**Memorandum
Planning and Urban Development Department
Planning Division**

To: Steve Bushey, PE, FST
From: Bill Needelman, Senior Planner
Date: August 19, 2013
Re: Canal Landing NewYard: Amended Site Plan Review Comments
CC: Barbara Barhydt, Development Review Services Manager
Dave Margolis-Pineo, Deputy City Engineer
Tom Errico, PE, TY Lin
David Senus, PE, Woodard Curran
Marge Schmuckal, Zoning Administrator

The following notes are based on the August 16, 2013 submission of the Canal Landing New Yard Amended Site Plan application for phasing the boat repair, storage and brokerage at 40 West Commercial Street. The New Yard was previously approved as a Level III site plan and conditional use by the Planning Board on December 18, 2012. The previous approval letter is attached (report omitted) for your reference. The applicant is now attempting to occupy the site at a limited level while offsite plans develop for a potential expansion of activity onto the subject site from the IMT property to the east.

PROJECT: CANAL LANDING  
 SHEET TITLE: SITE DEVELOPMENT PLAN PHASE 1A (SUMMER/FALL 2013) AND 1B (DATE UNDETERMINED)  
 CLIENT: NEW YARD LLC  
 58 FORE STREET  
 PORTLAND, ME 04101

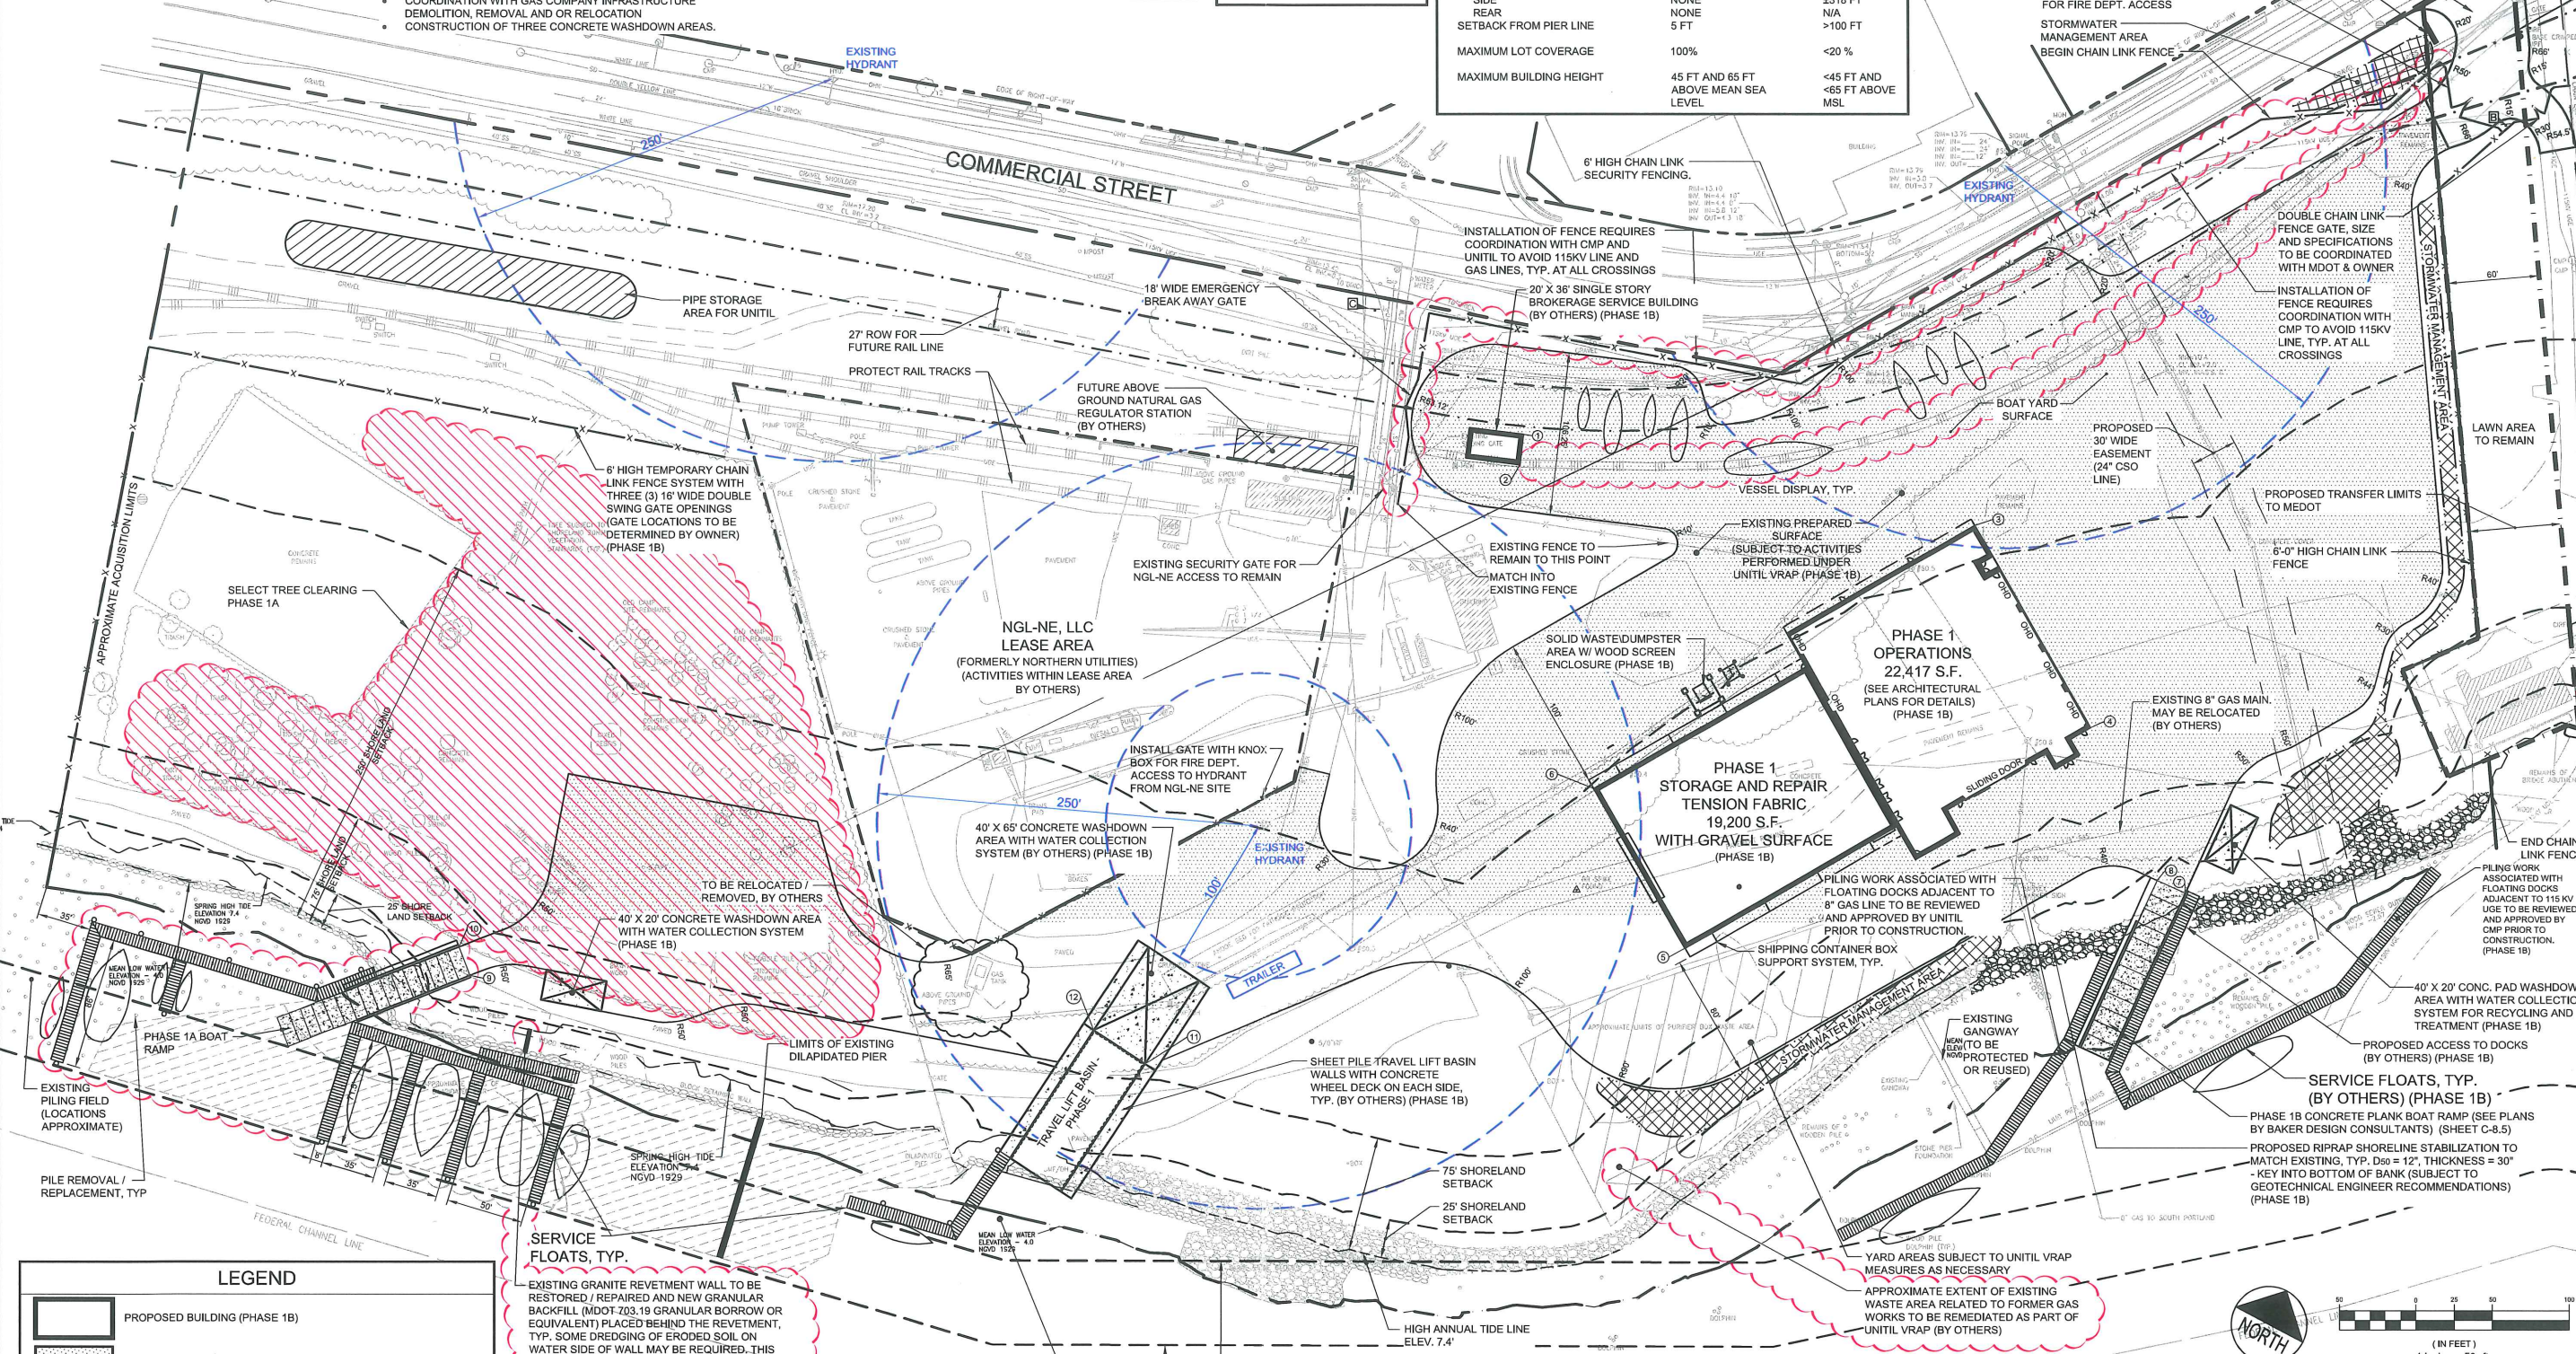
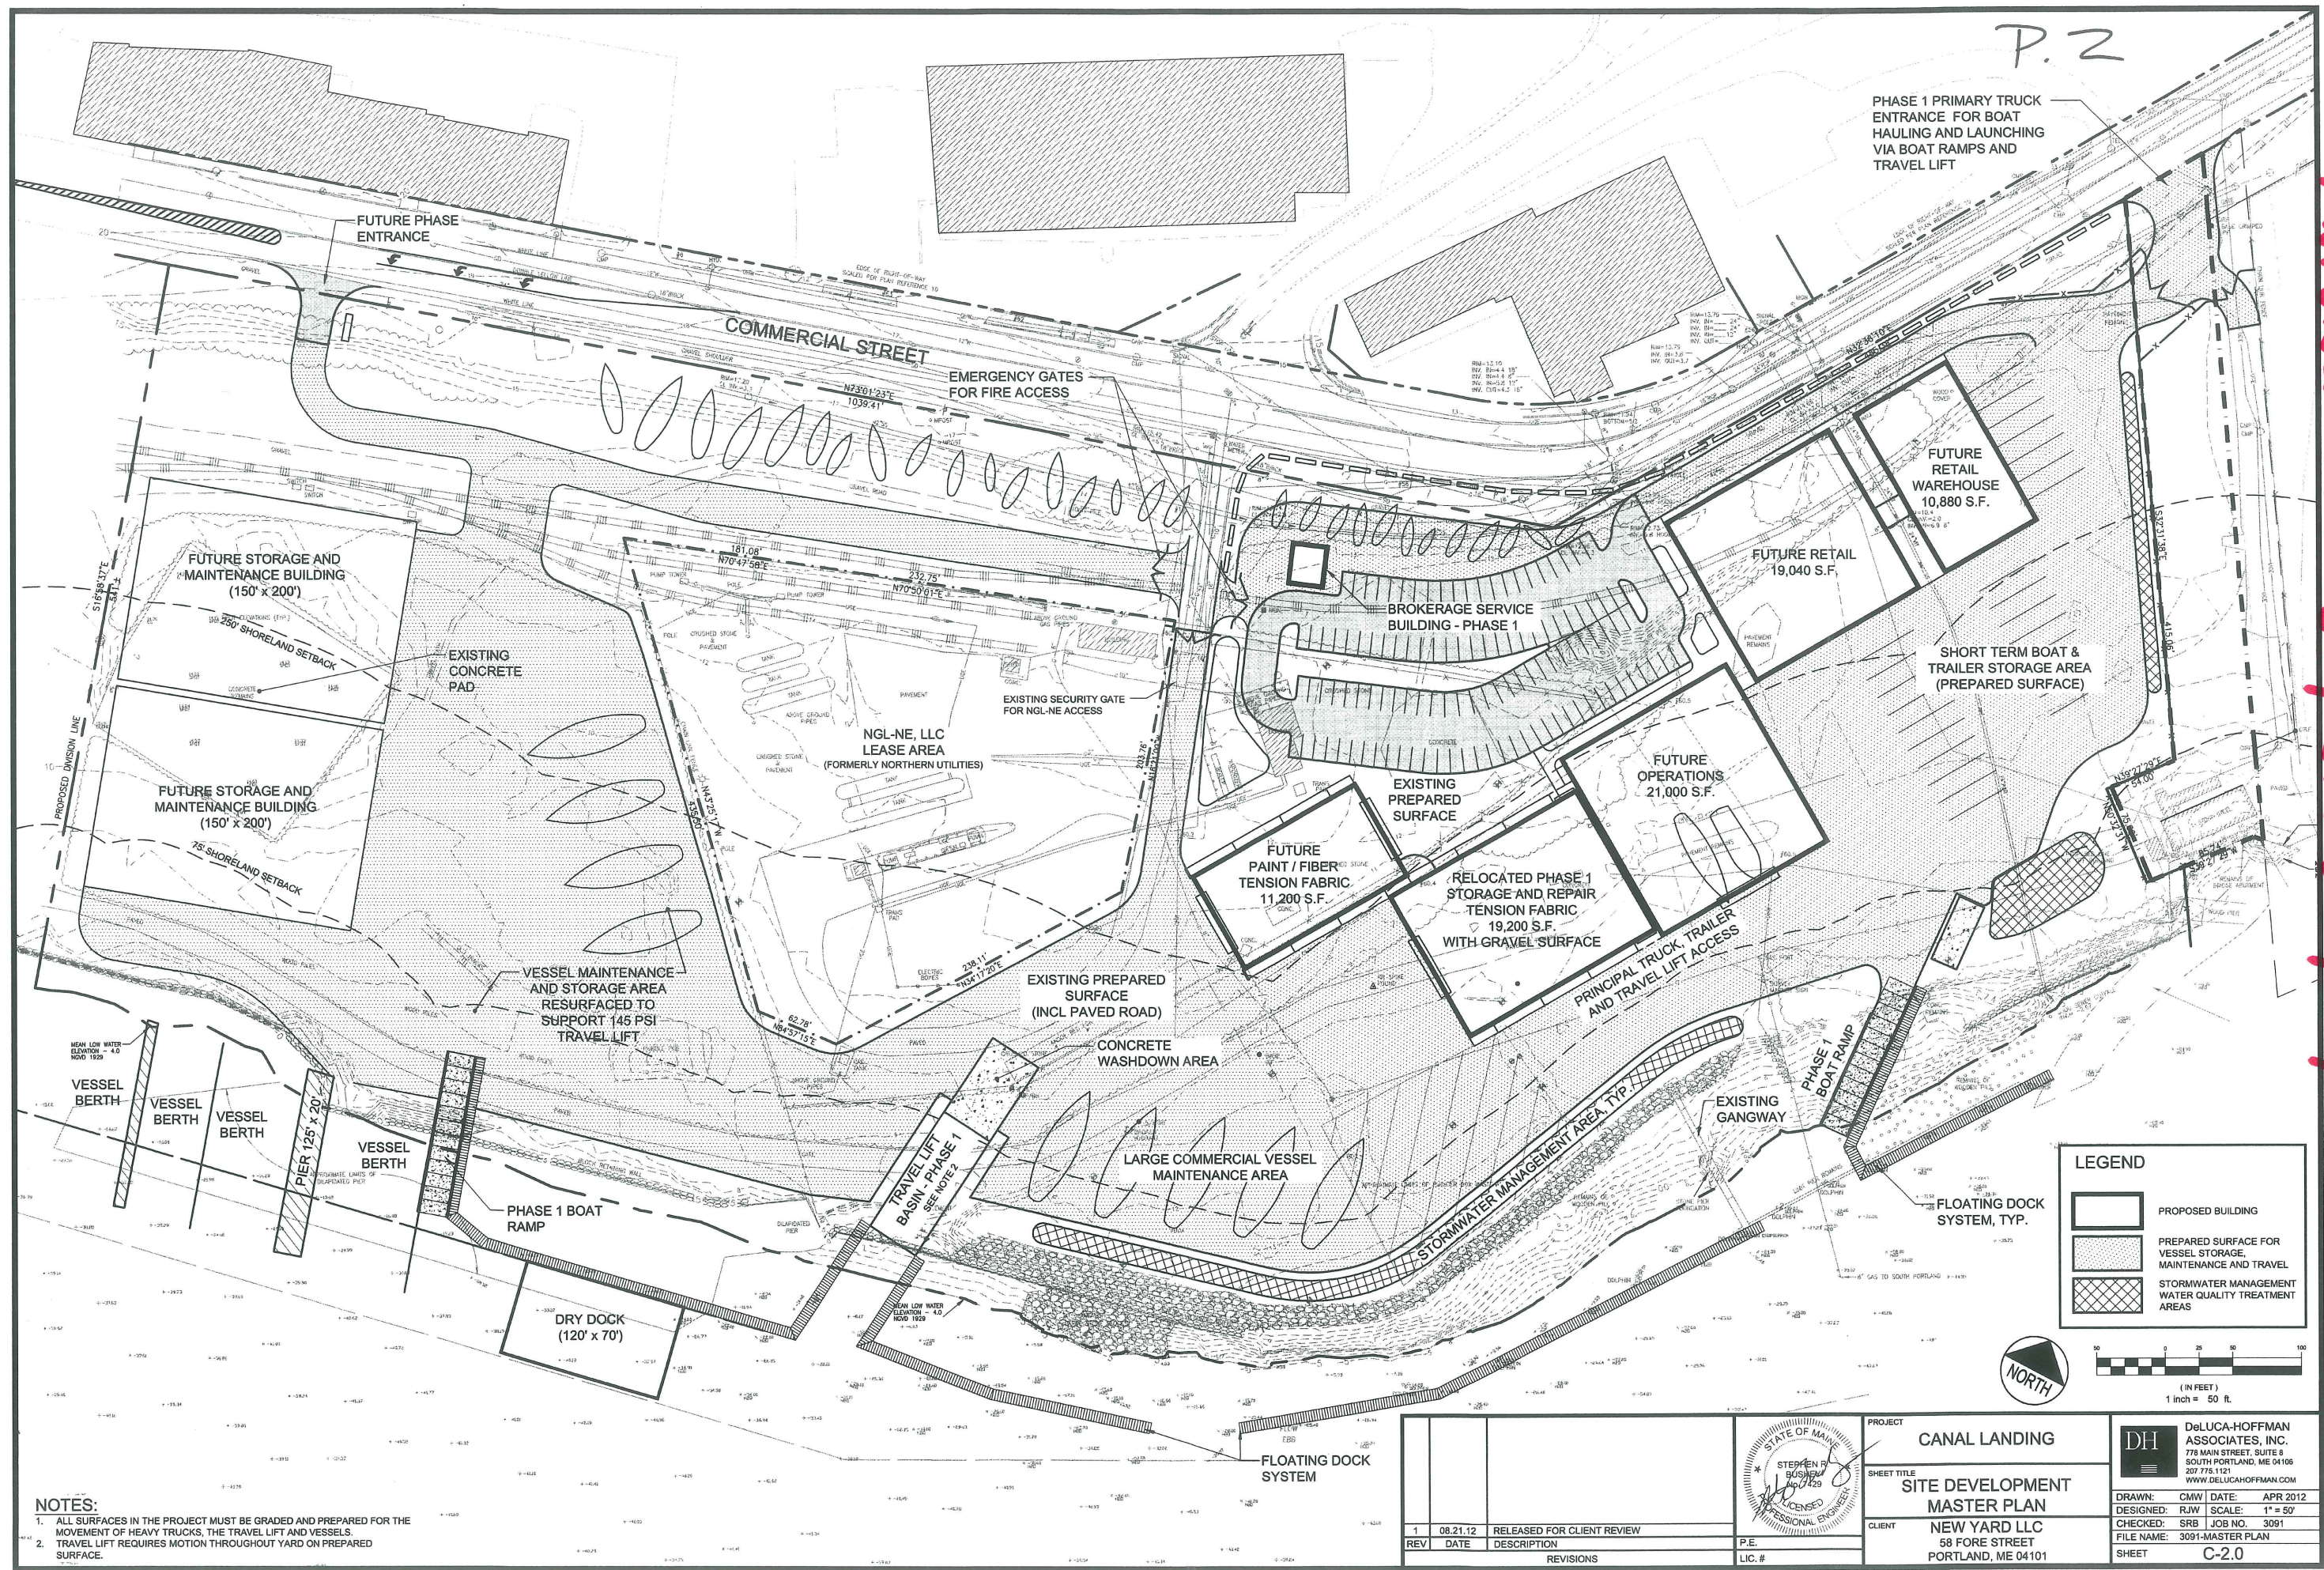
- The proposed construction trailer is not shown on the phasing plan. If the trailer is proposed for use beyond the construction of phase 1a improvements: show the location and extent of utility connections; locate the nearest existing fire hydrant; and, describe/show circulation and emergency access to the structure.
- Regarding the westerly boat ramp: Will a wash down area be improved with the construction of the ramp? If not, where will wash down activity take place and what means to control discharge to the bay will be employed?
- The application narrative describes “boat repair activities” to be approved with phase 1a. Please describe in greater detail.
- The application narrative proposes “no permanent underground utilities will be installed.” Please describe the extent of both overhead and temporary underground utility proposed.
